Subject: App 2022/93452 Land South of 5 - 25 Clay Well, Golcar, Huddersfield - Discharge of Conditions
Date: 01 December 2022 15:06:13

DRAWING
Proposed Site Layout

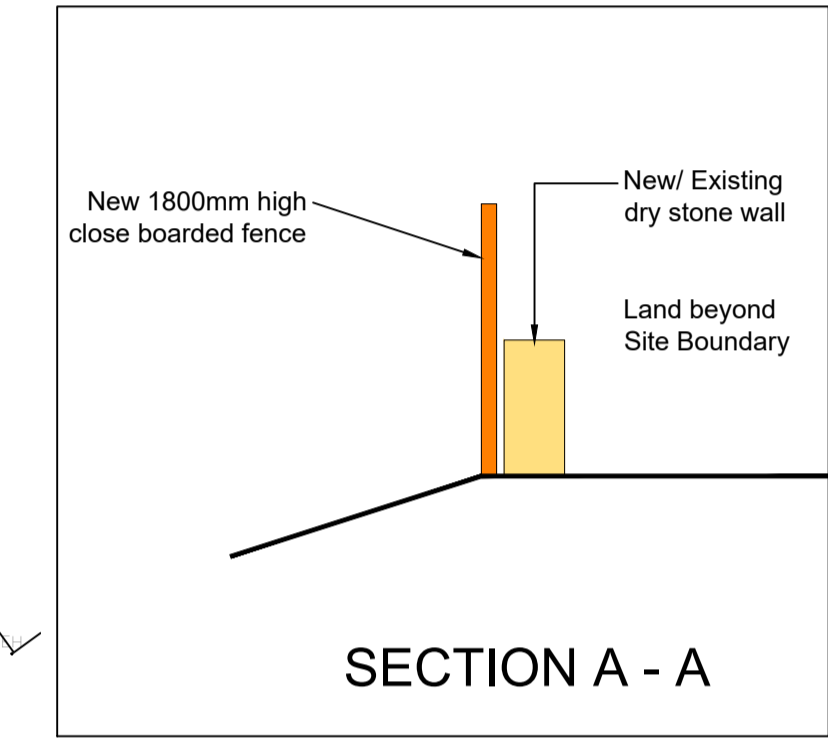
Condition 20 (Crime Prevention) - The security measures for the security of cycles in the sheds will be acceptable.

It is taken that the door and windows security standards will comply with the Part Q Building Regulations and be to a minimum of the new PAS 24:2022 standard; or PAS 24:2016 until September 2024. This confirmation **will be** required to be able to fully discharge this condition.

DATE: 30 July 2022
DESIGNER: SHD Lighting Consultancy Ltd
PROJECT No: SHD666
PROJECT NAME: Hillcrest View, Huddersfield

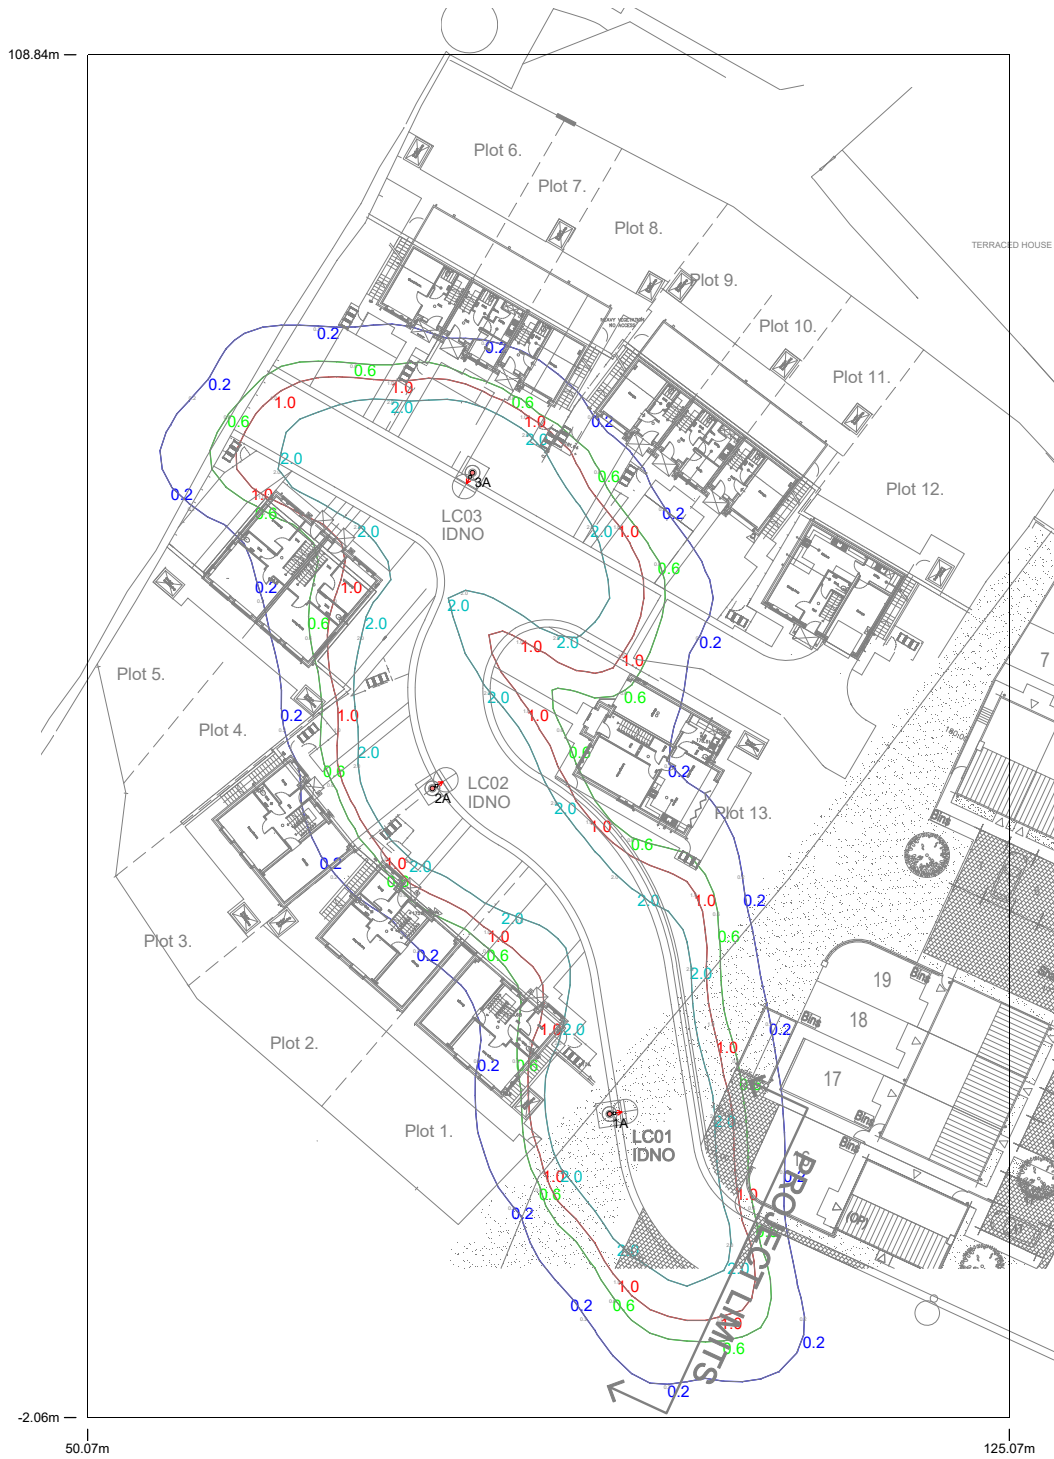
Condition 24 (External Lighting) - With reference to Drawing Number - SHD666-SHD-HLG-HILL-DR-EO-Lighting Layout-R0 dated 30/07/22. The shown lighting spread from column LC03 does not give sufficient light spill to the drive and side of Plots 12 and 13.

In order to discharge this **Condition 24**, I would recommend that either column LC03 be moved closer to the private drive of Plot 12 and an additional column be installed in the vicinity of Plots 5 or Plot 6. This would have to be agreed with the Kirklees Council Lighting Team. Another option would be to install dusk to dawn lighting to the frontages of Plots 12 and 13, ensuring there is enough illumination of the private drive.

Therefore, at present **Condition 24 (External Lighting)** is **NOT Discharged**.
